Address: 135 Upper Batley Lane Batley WF17 0QT

Application number: 2024/90851	
What is the application for?:	Erection of two storey front and rear extensions and single storey side extensio
Address of the site or building:	216, Woodlands Road, Batley, WF17 0QS
Postcode:	WF17 0QS

Type of comment: An objection	
Do you wish your comments to be published on the website anonymously?	No

PROPOSED REAR ELEVATION
Scale 1:50@A1

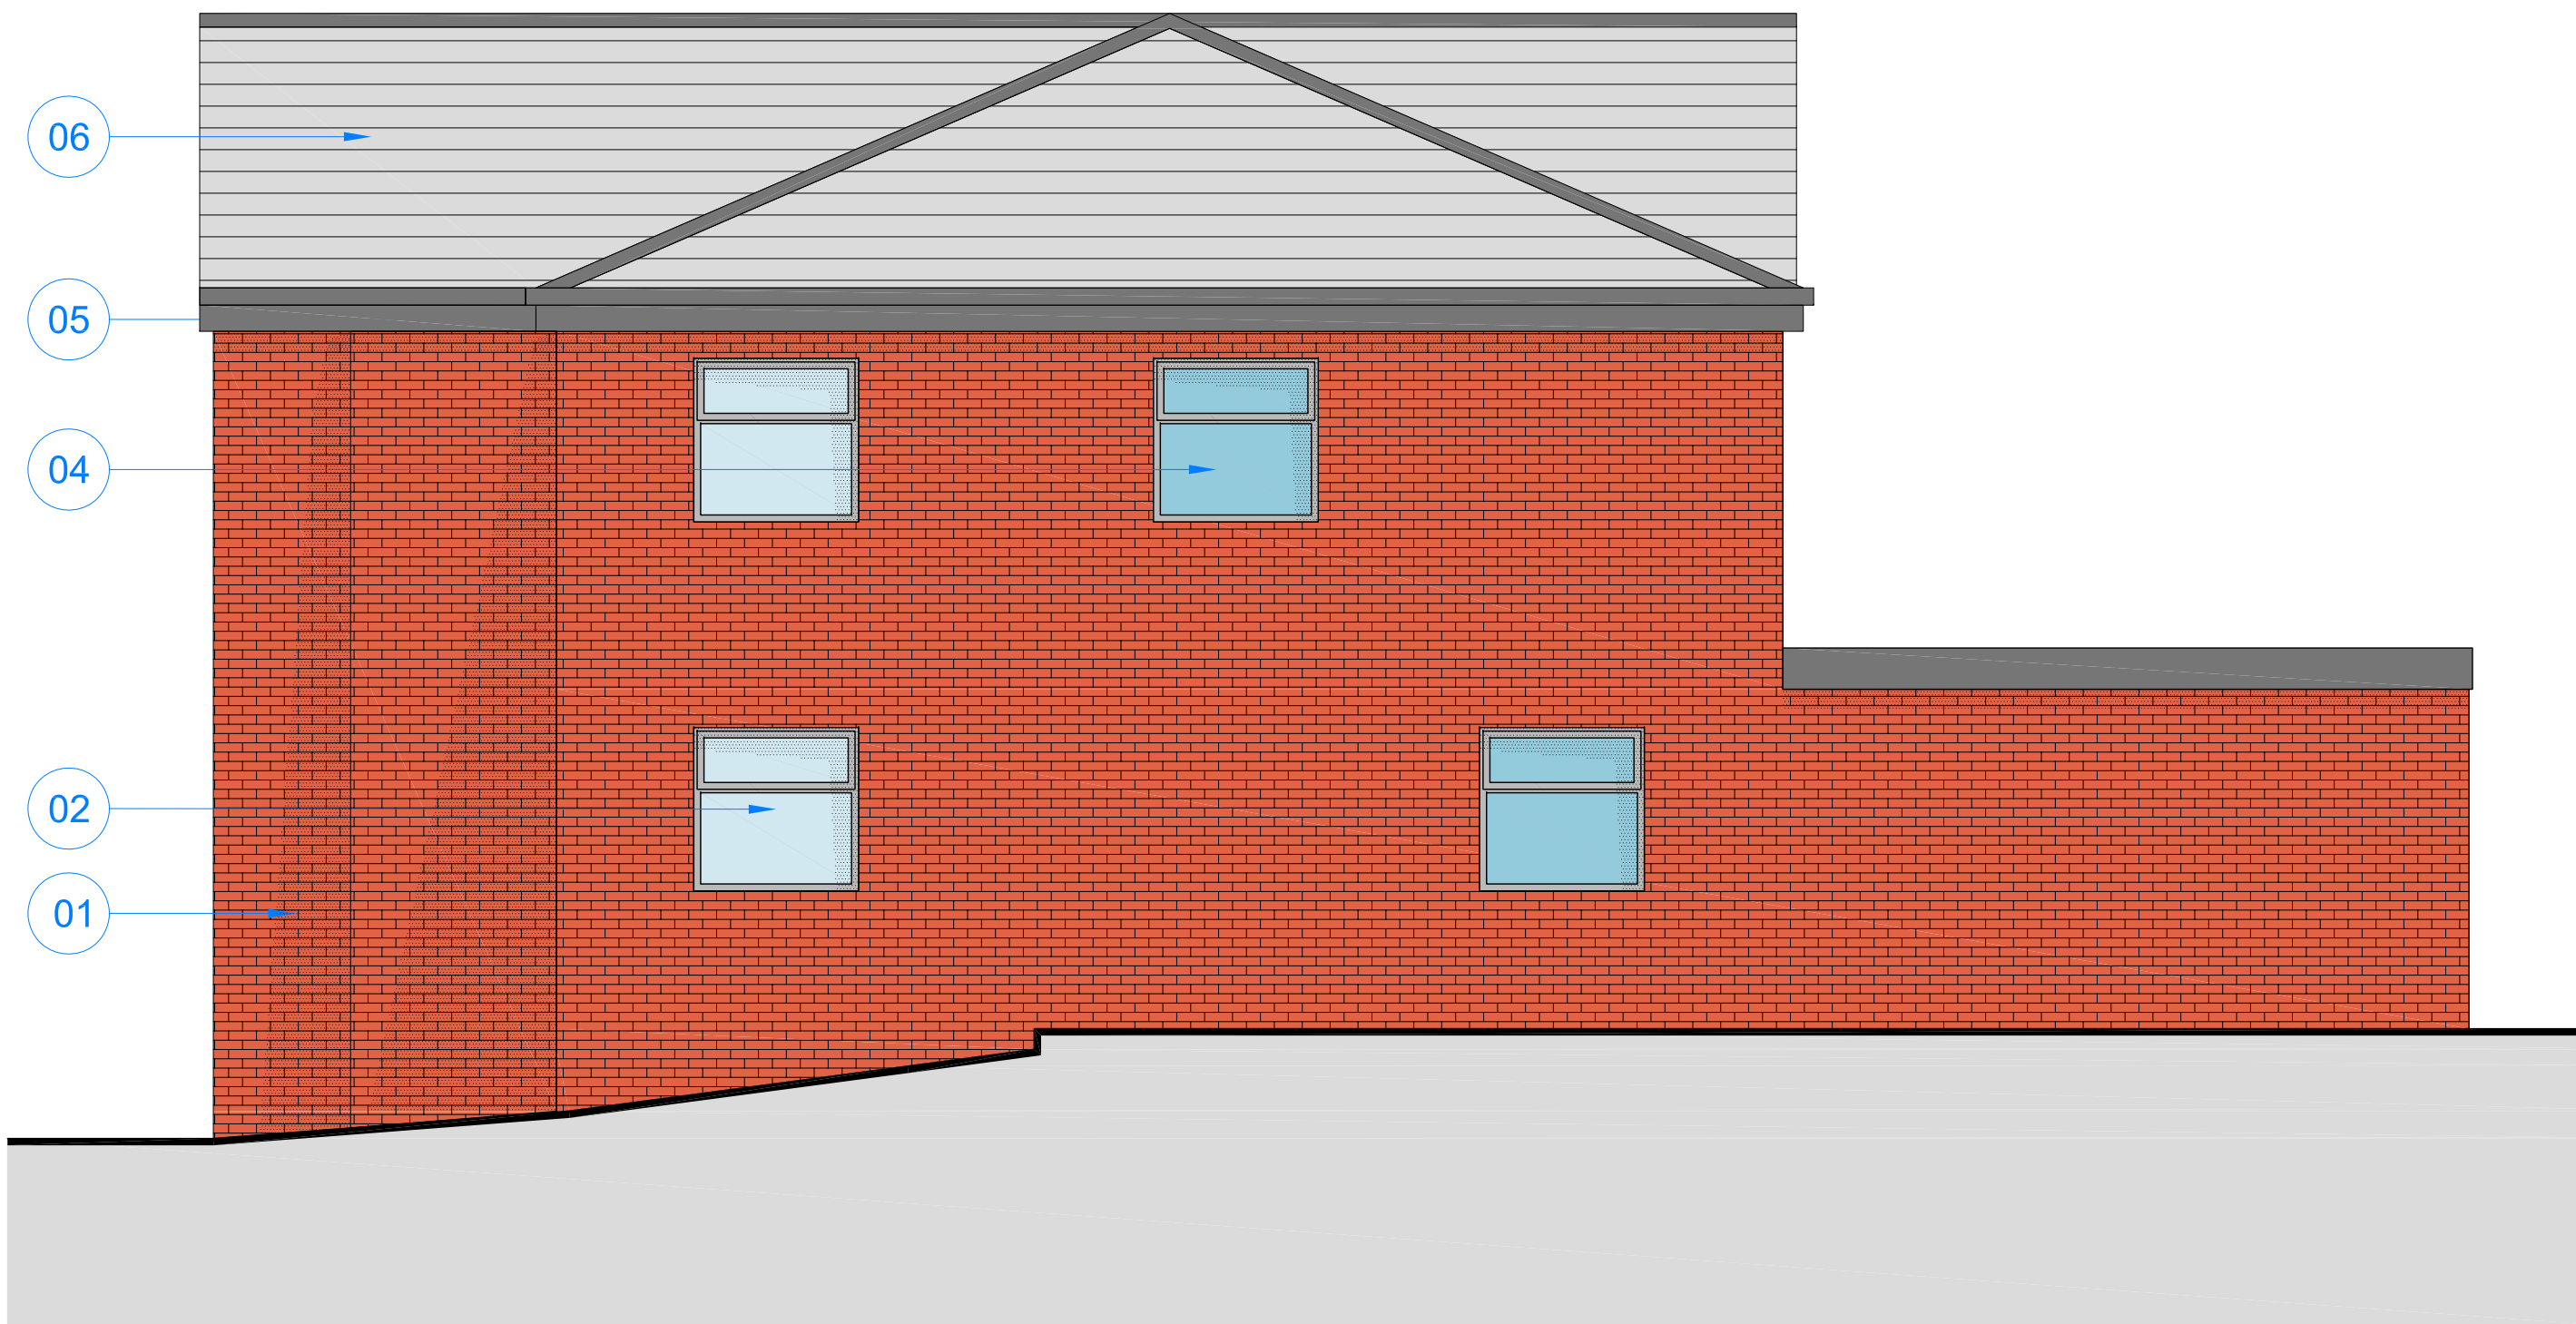
The double storey side extension would affect privacy and sunlight to the neighbour to the rear- 135 Upper Batley Lane. It appears that the planned windows would look straight onto their patio, thereby also allowing an undesired view from 135 straight into the proposed bedrooms. The rear wall to the extension has a full height window which could become a door leading onto the flat roof. This could cause future problems if it were used for other purposes.

PROPOSED GROUND FLOOR PLAN
Scale 1:100@A1

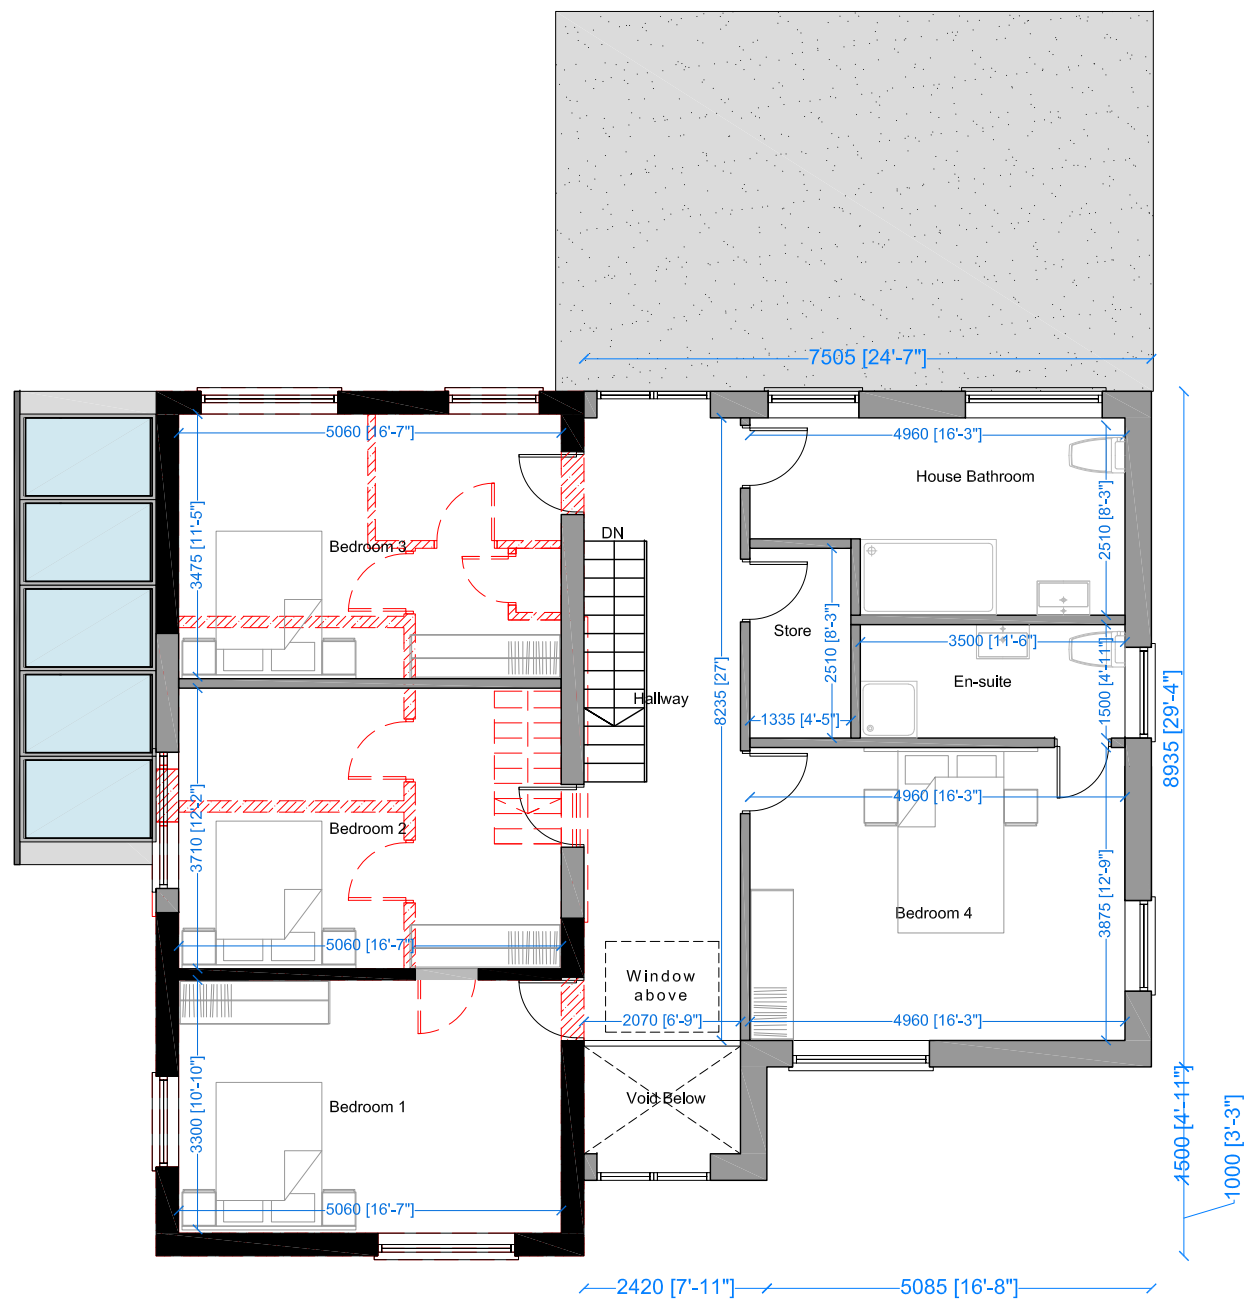
The neighbourhood will be impacted by the proposed loss of garage and reduction of driveway space, and the quiet neighbourhood and junction position will likely become congested and unsafe to pass by with the additional vehicles parked on the roadside that such a highly occupied property will bring.

PROPOSED ROOF PLAN
Scale 1:100@A1

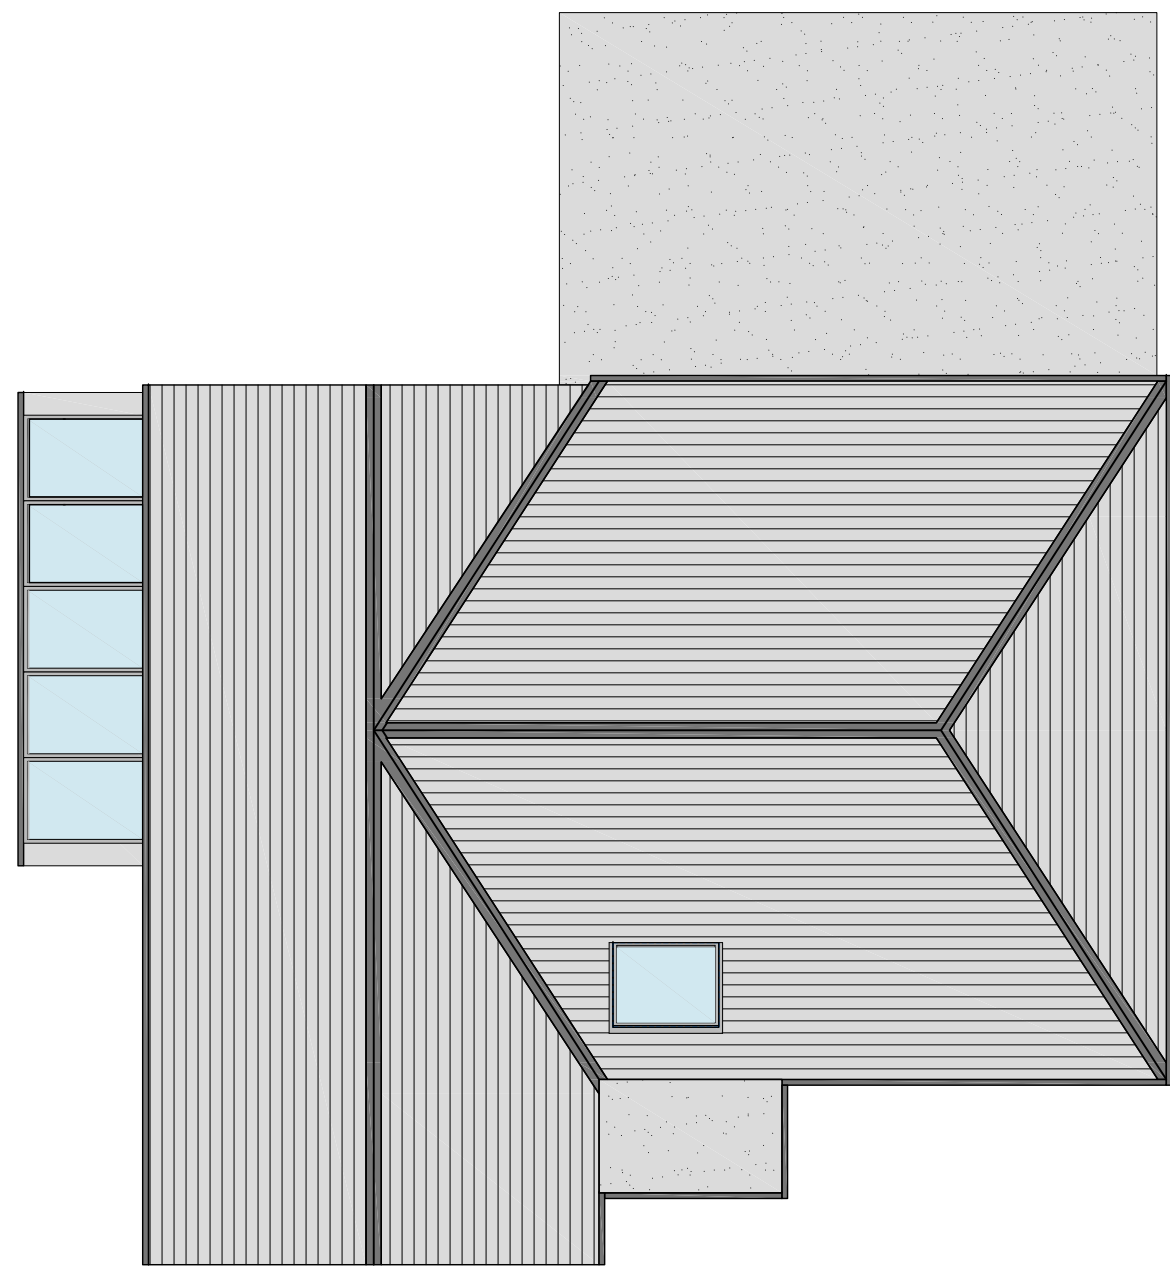
The new flat roofed area is enormous and is over a living area which although now single storey is considerably wider. It does not seem normal to provide such a vast expanse of flat roofing and insurance companies these days seem to frown on that method of construction as it does cause problems.
